From: [REDACTED]
To: [Hinckley SRF](#)
Subject: Application by Tritax Symmetry (Hinckley) Limited ("the Applicant") Seeking Development Consent for the Proposed Hinckley National Rail Freight Interchange Project ("the Proposed Development")
Date: 07 February 2025 14:49:31
Attachments: [REDACTED]

Hinckley Rail/Freight Interchange proposal – List of equestrian concerns March 2022

BRIDLEWAY UNDERPASS GENERAL ARRANGEMENT
SCALE 1:500

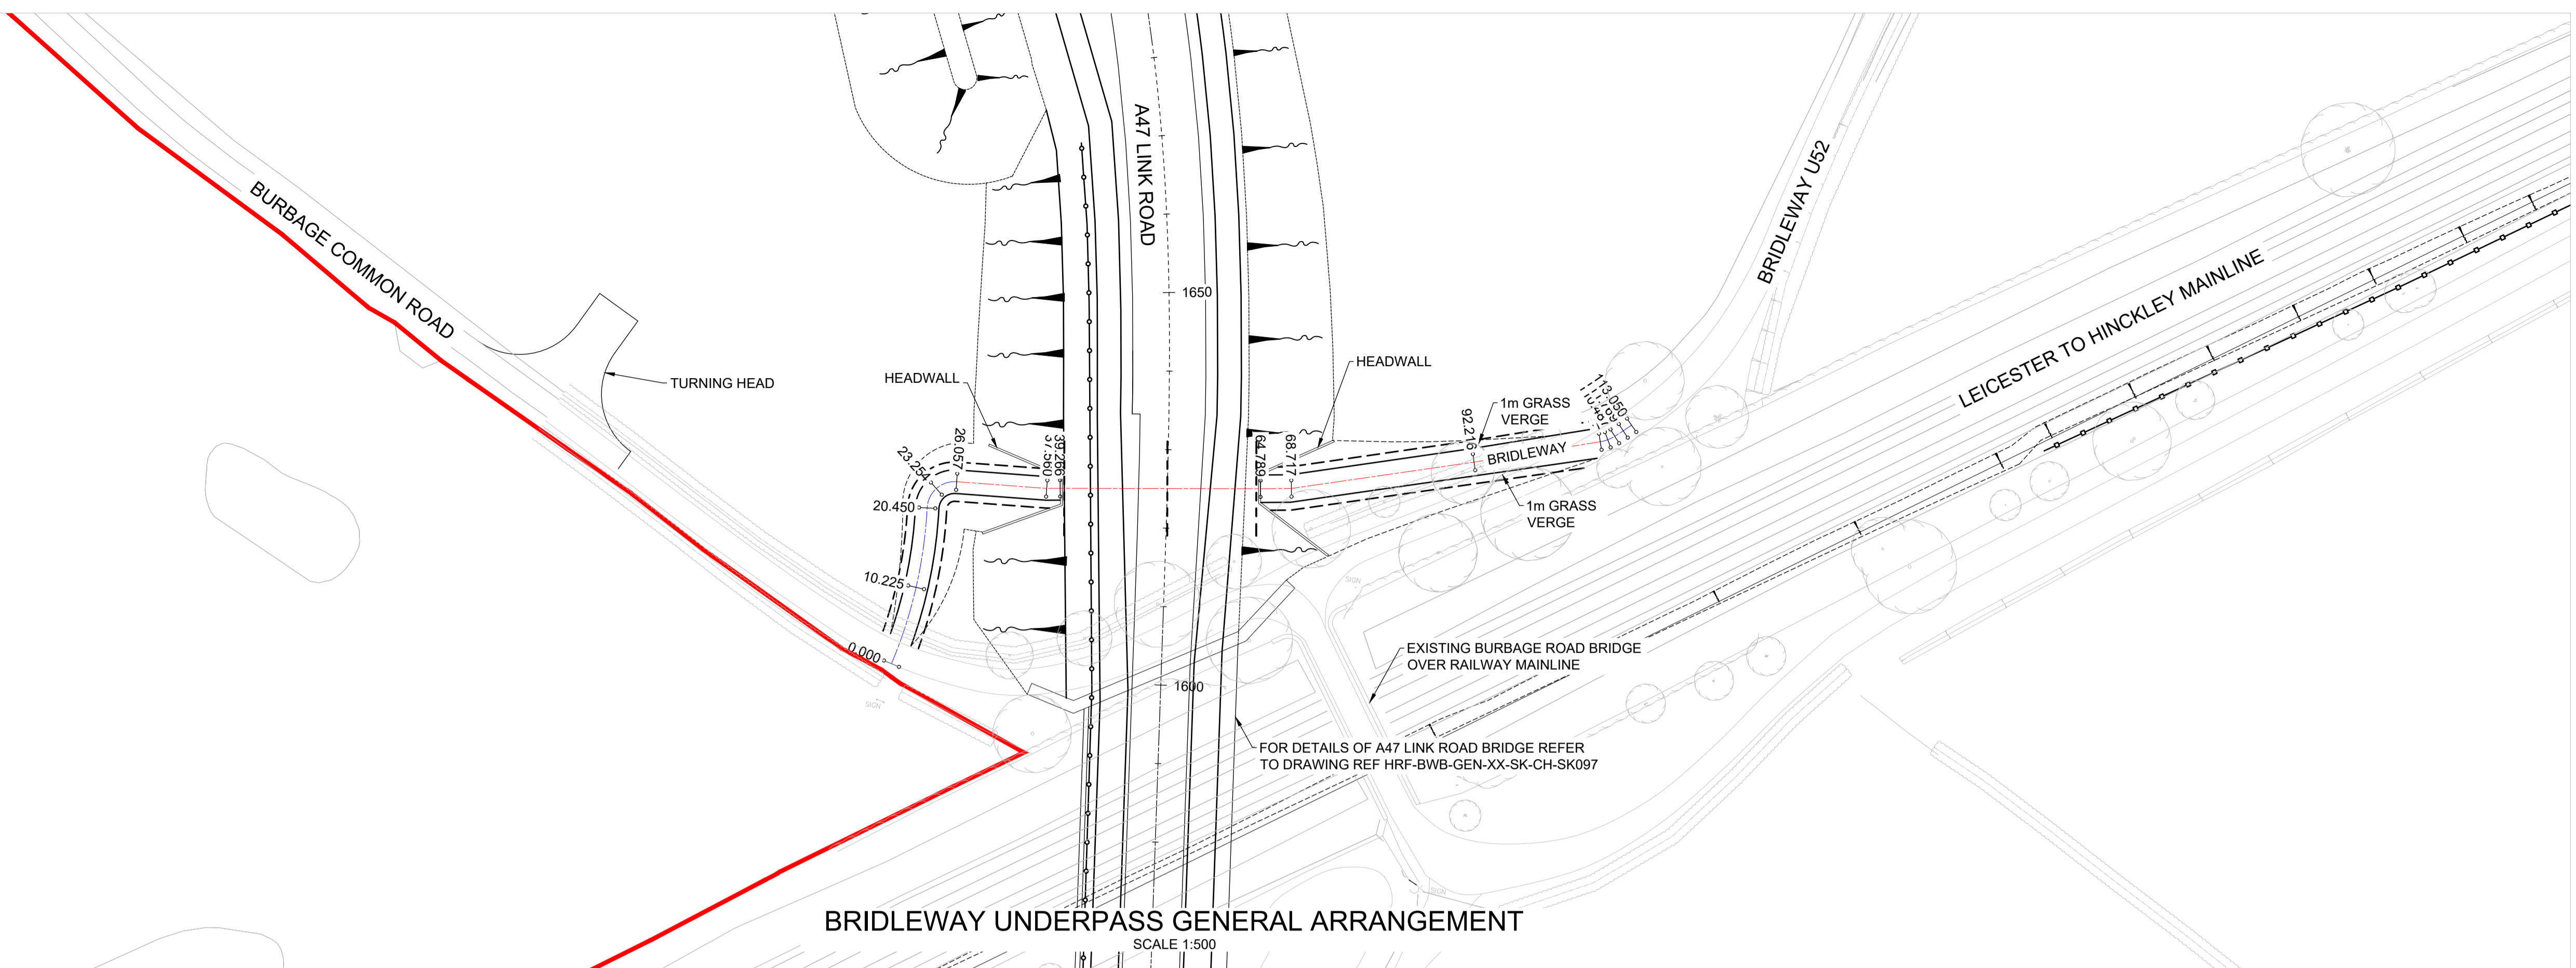
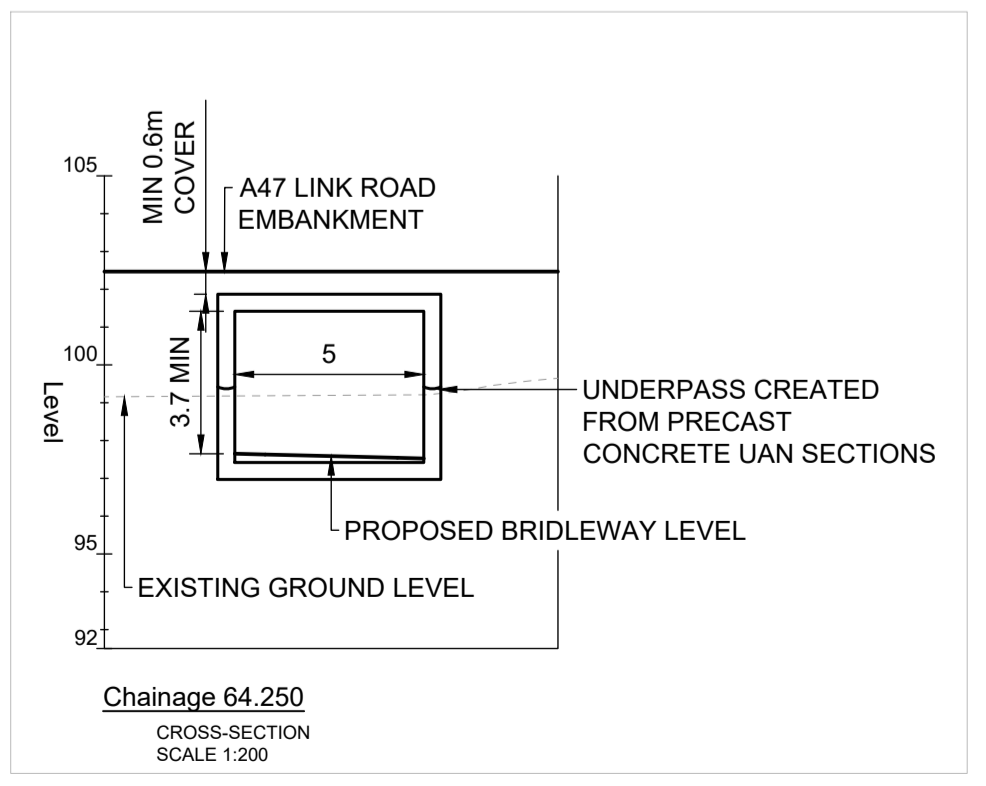
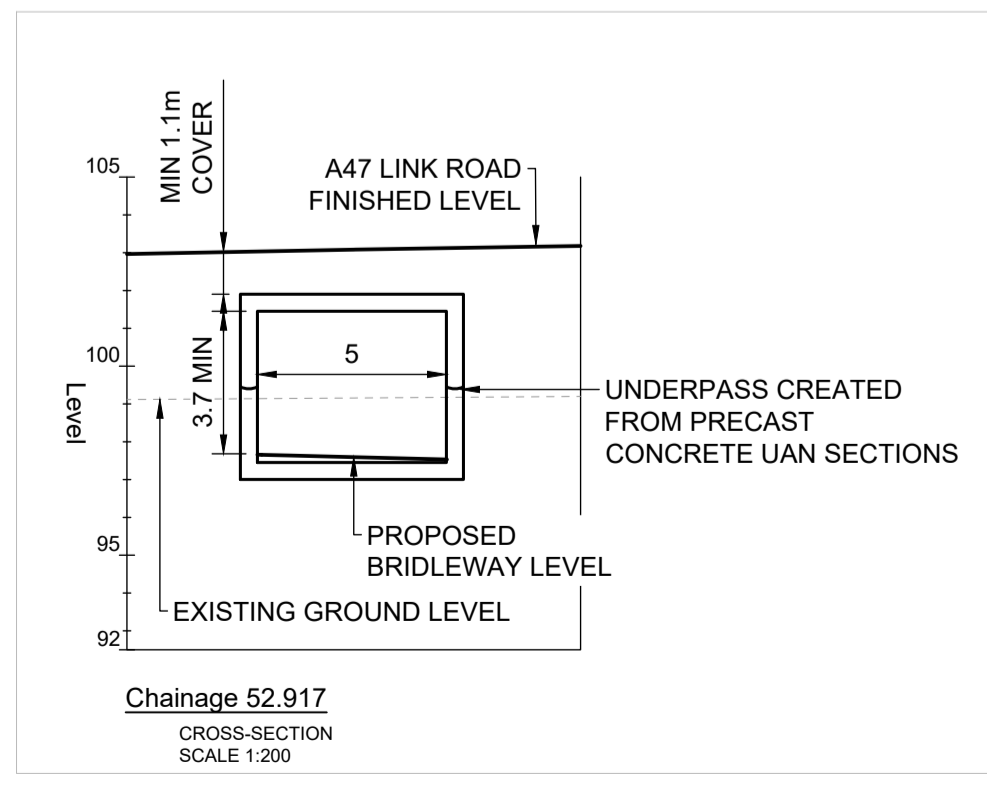
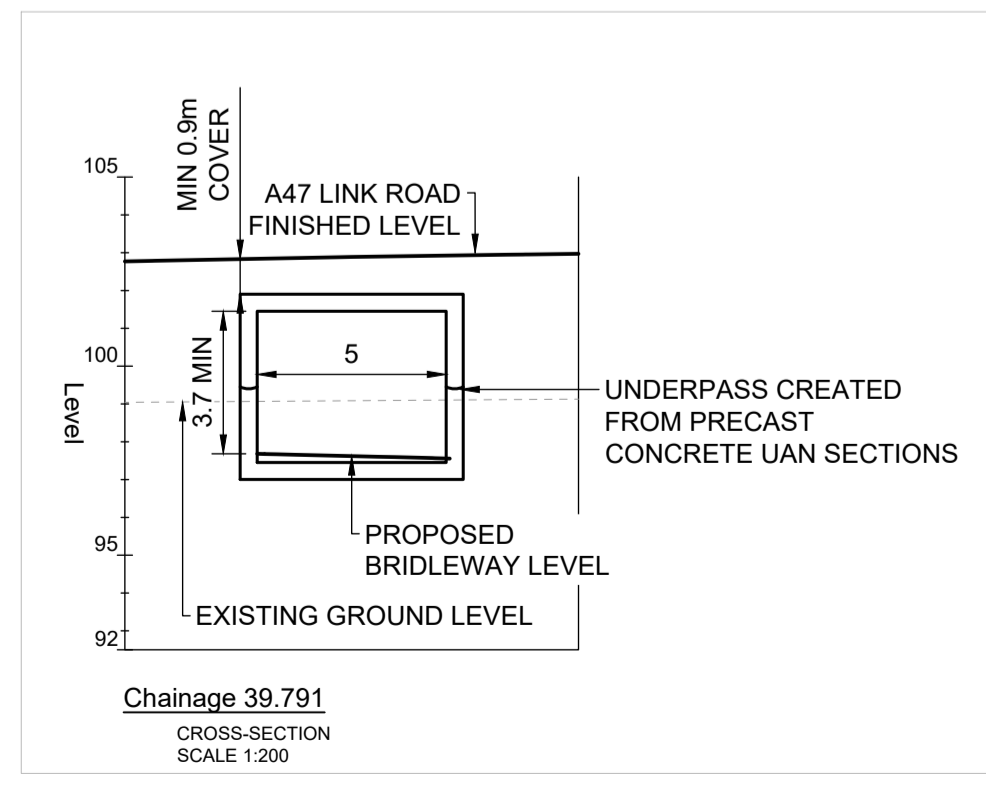
We welcome the provisions planned into the site for horse riders and other non-motorised users. Particularly that an alternative is provided for the disrupted Burbage Common Road in the site and with an underpass of the new road to connect to Burbage Common. Nevertheless, some long-term and construction period issues need to be addressed.

12. Planned bridleway around north and east edges of the site between Burbage Common Road and the M69 Junc 2 roundabout needs to be in place before the PRow network is disrupted by construction. This would also give the vegetational screening time to grow/mature. NB species need to be chosen with care so they do not obtrude into the usable area at less than 4m height, particularly where the track is to the south of the planting, where branch length is likely to be longer.
